19/11/2021

**Sydney Olympic Park New High School (SSD-11802230)
Response to Submissions**

ATTACHMENT 1 – KEY ISSUES

Sheet title
SSDA
Proposed Elevations

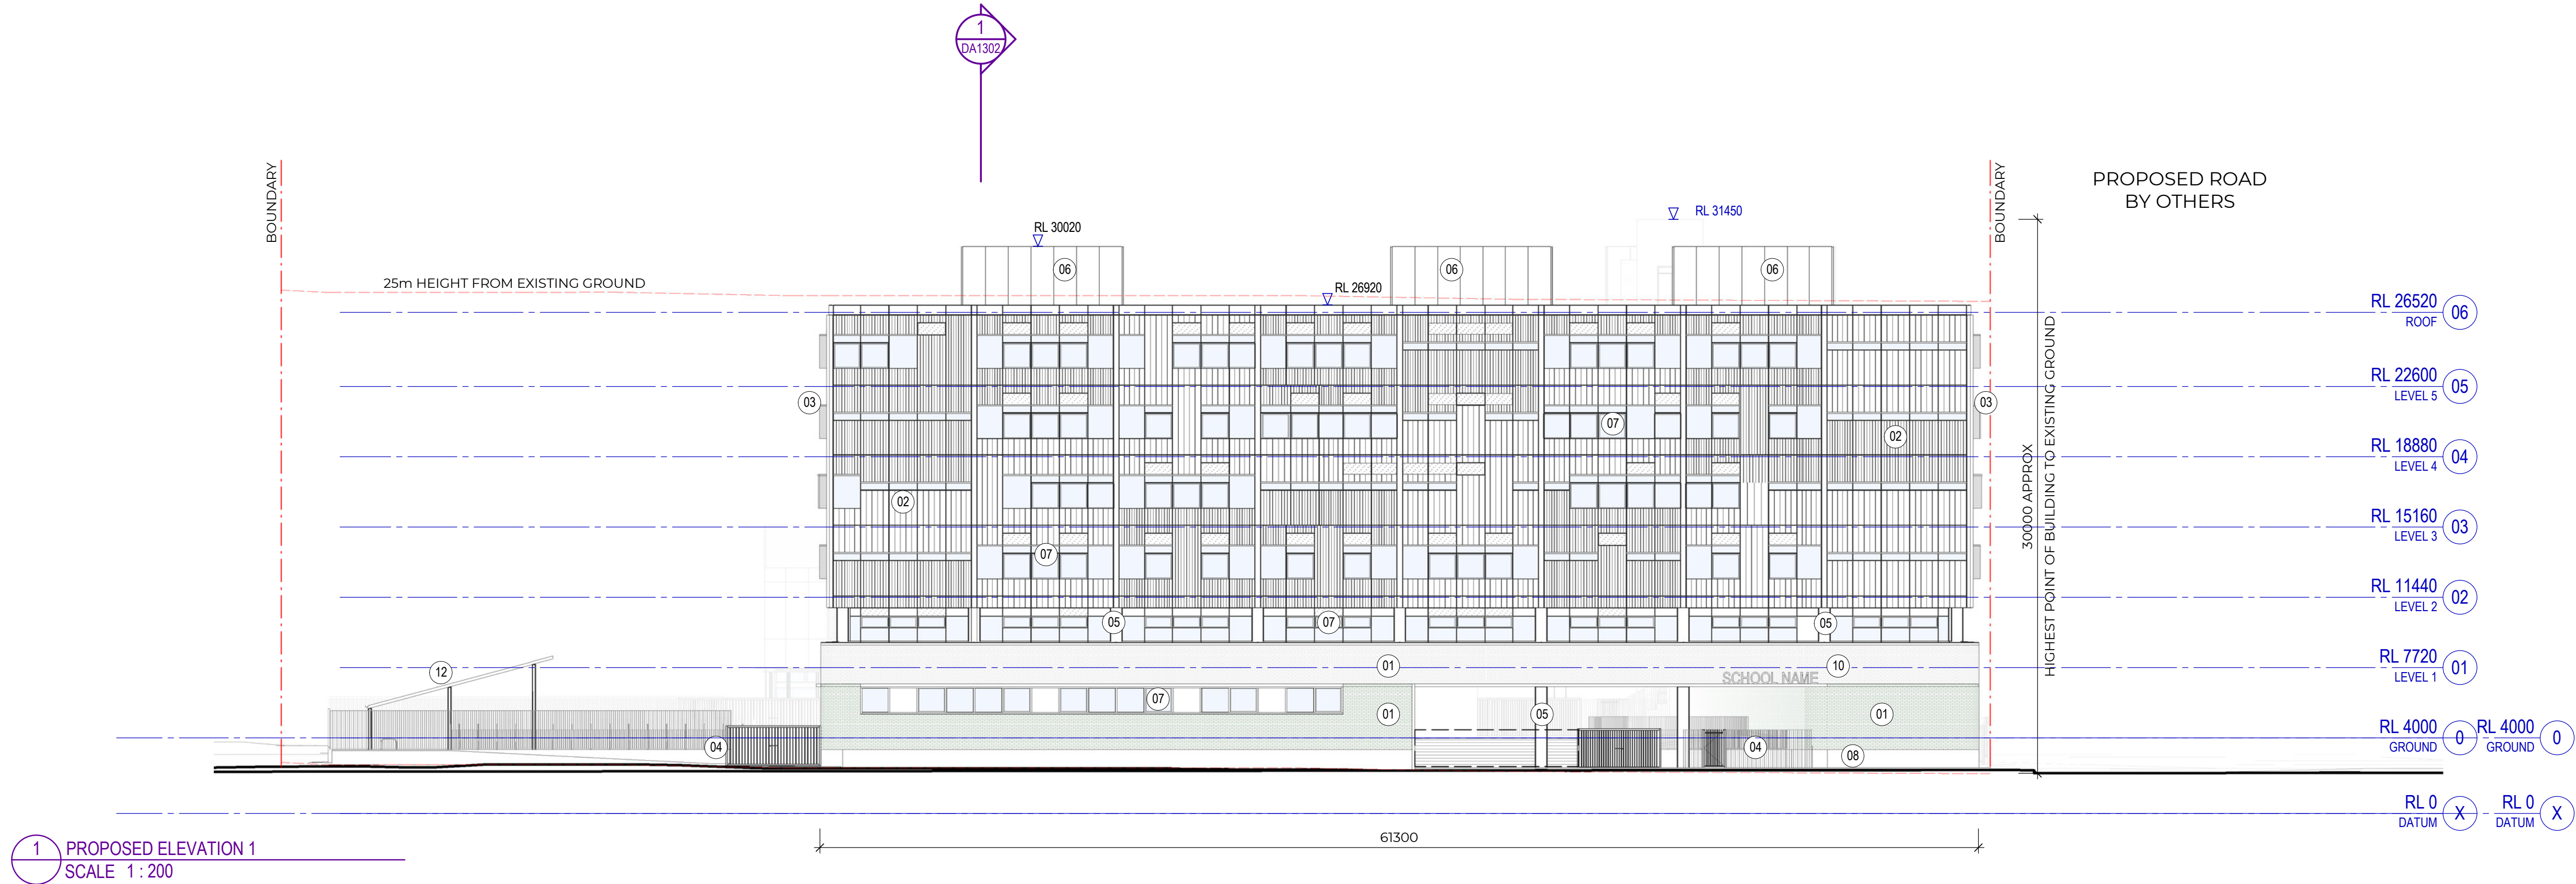
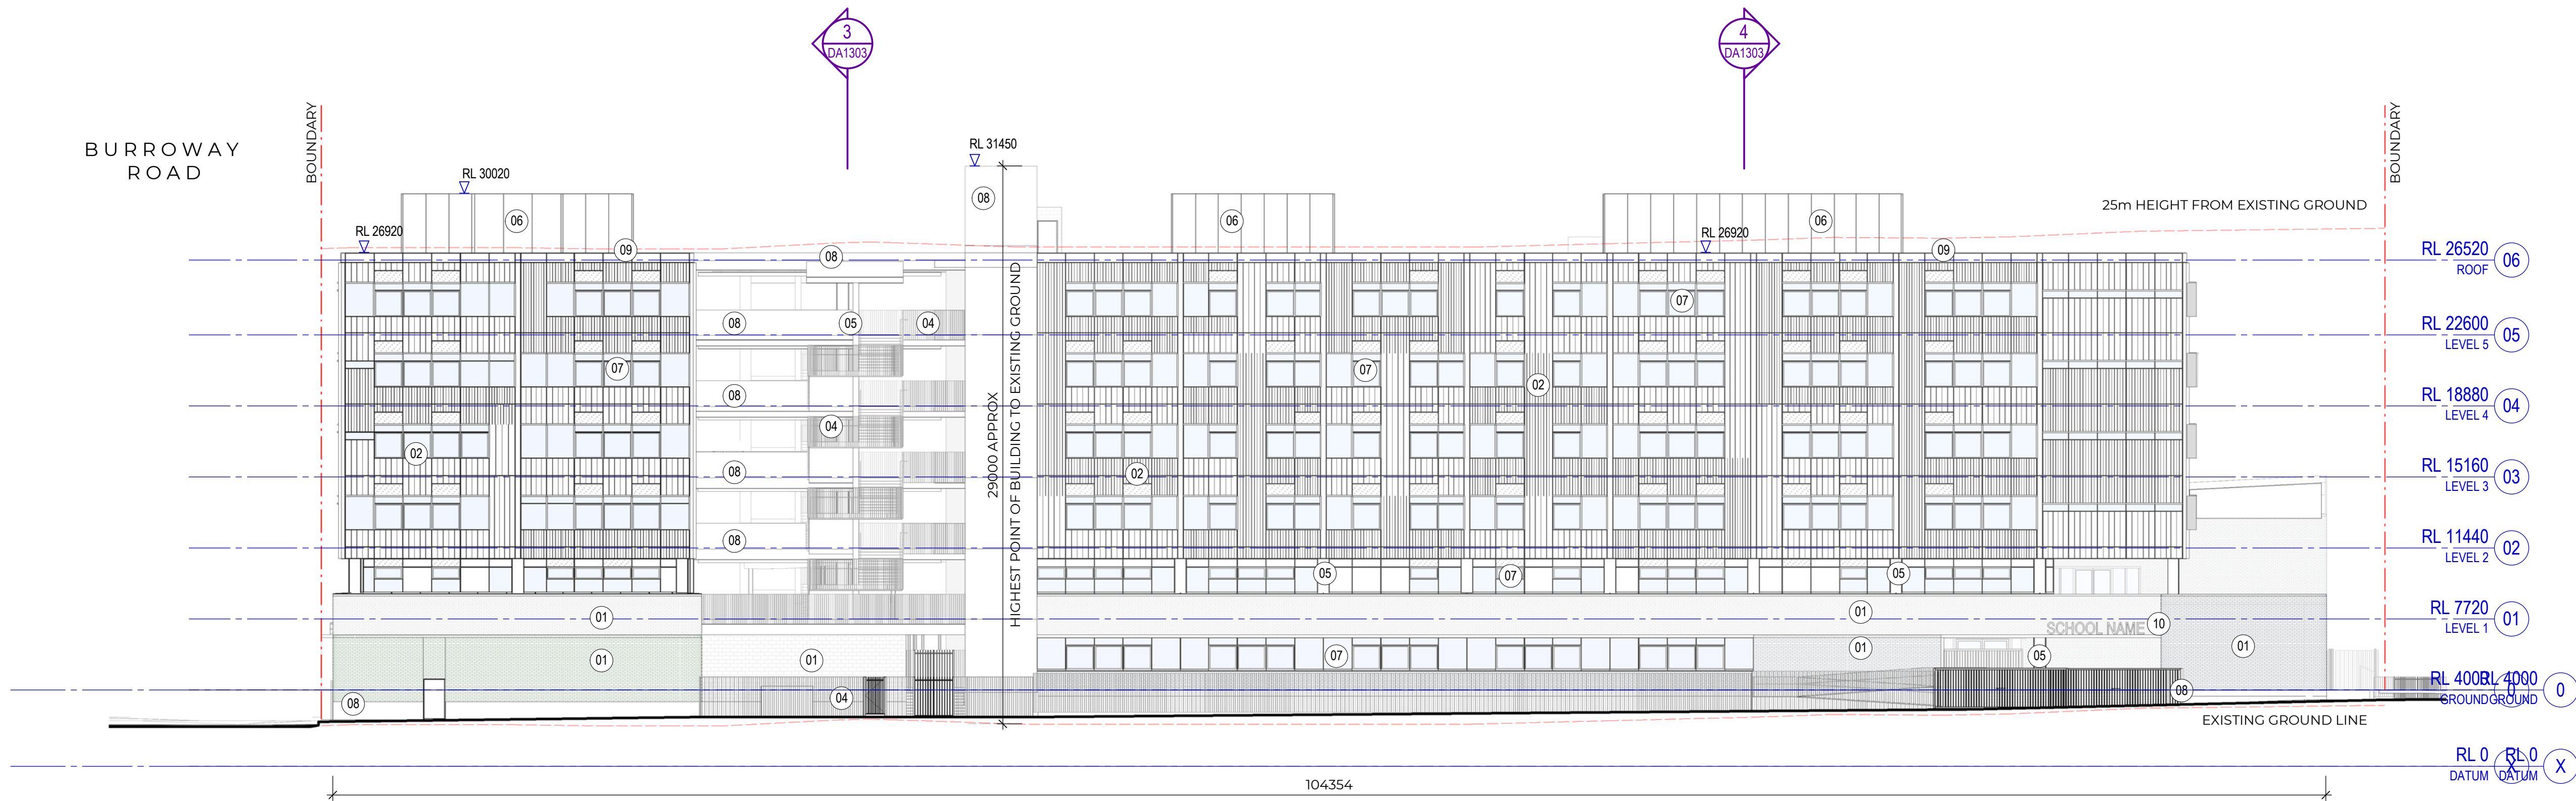
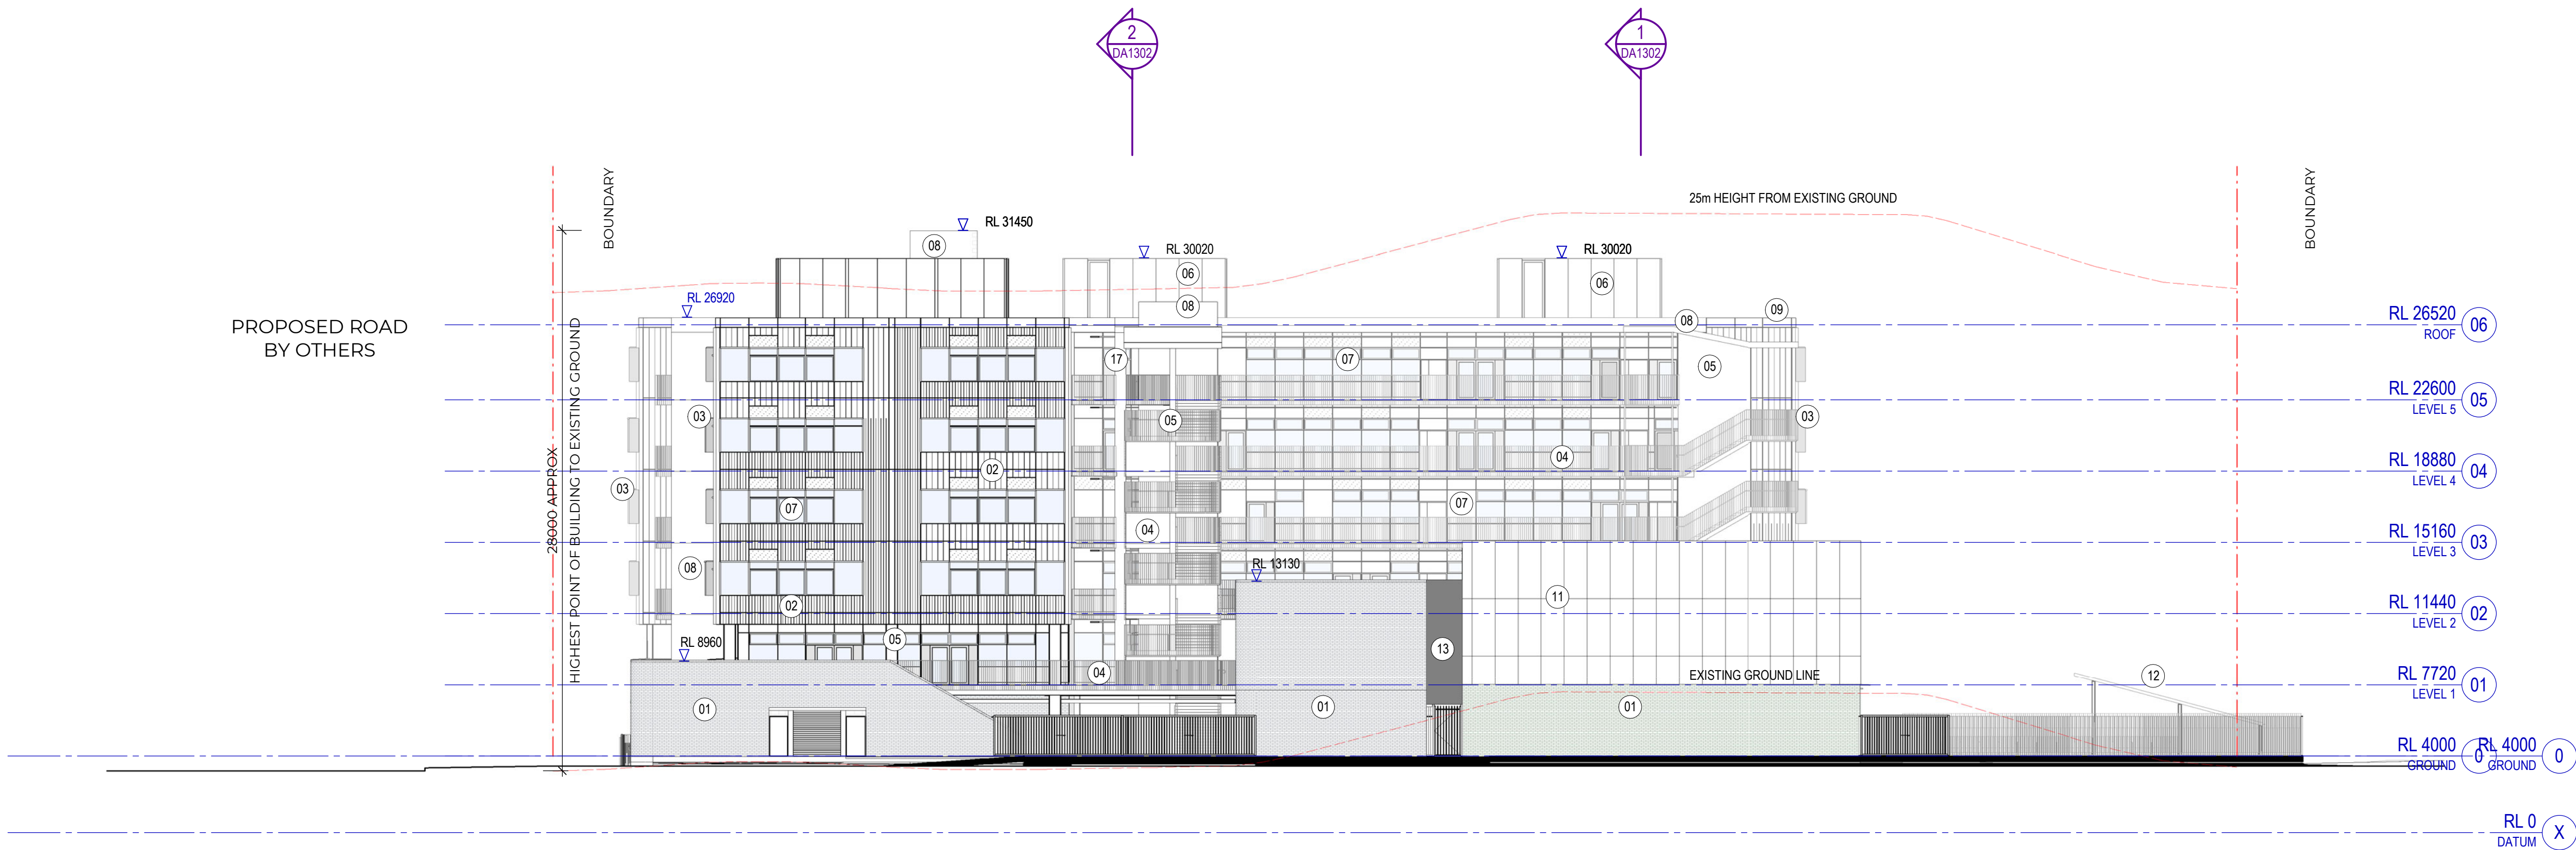
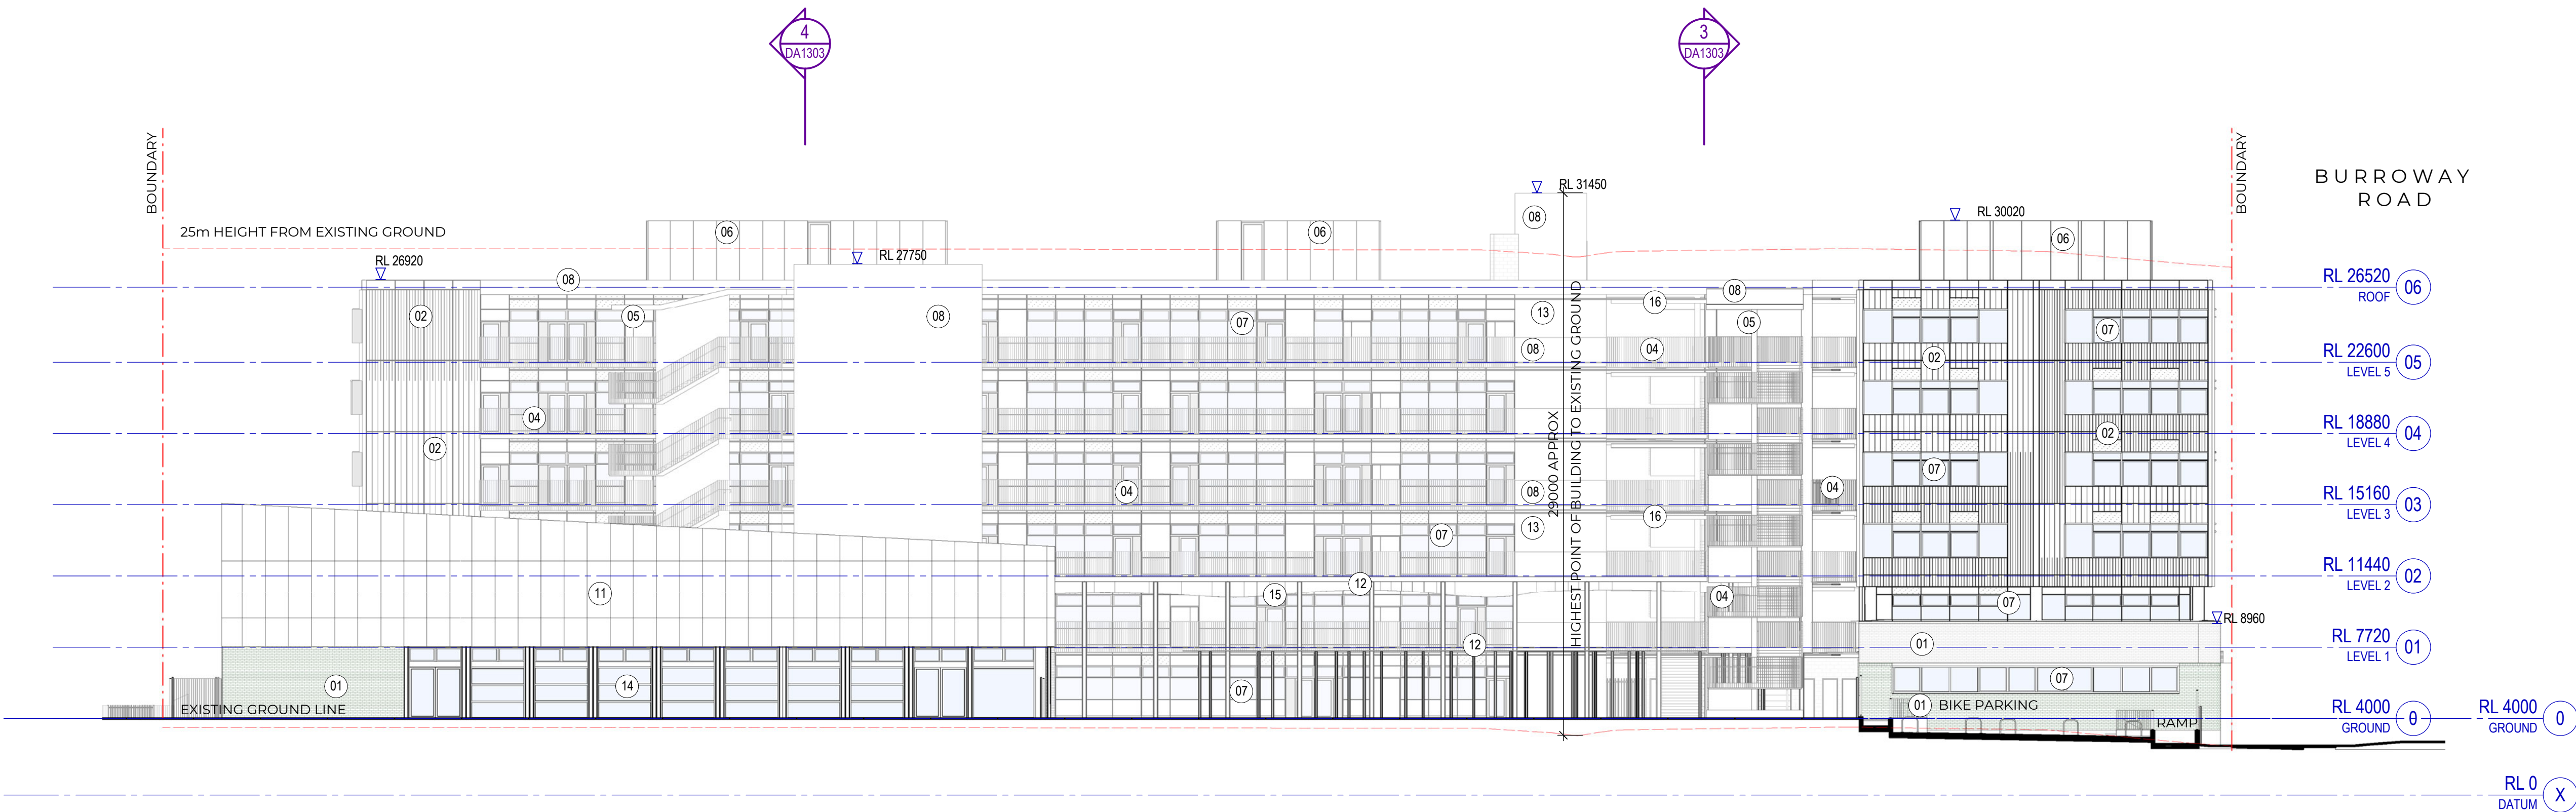
- further details relating to façade details/articulation, materials used for courtyard and external walkways and the nature of solar protection to classrooms.
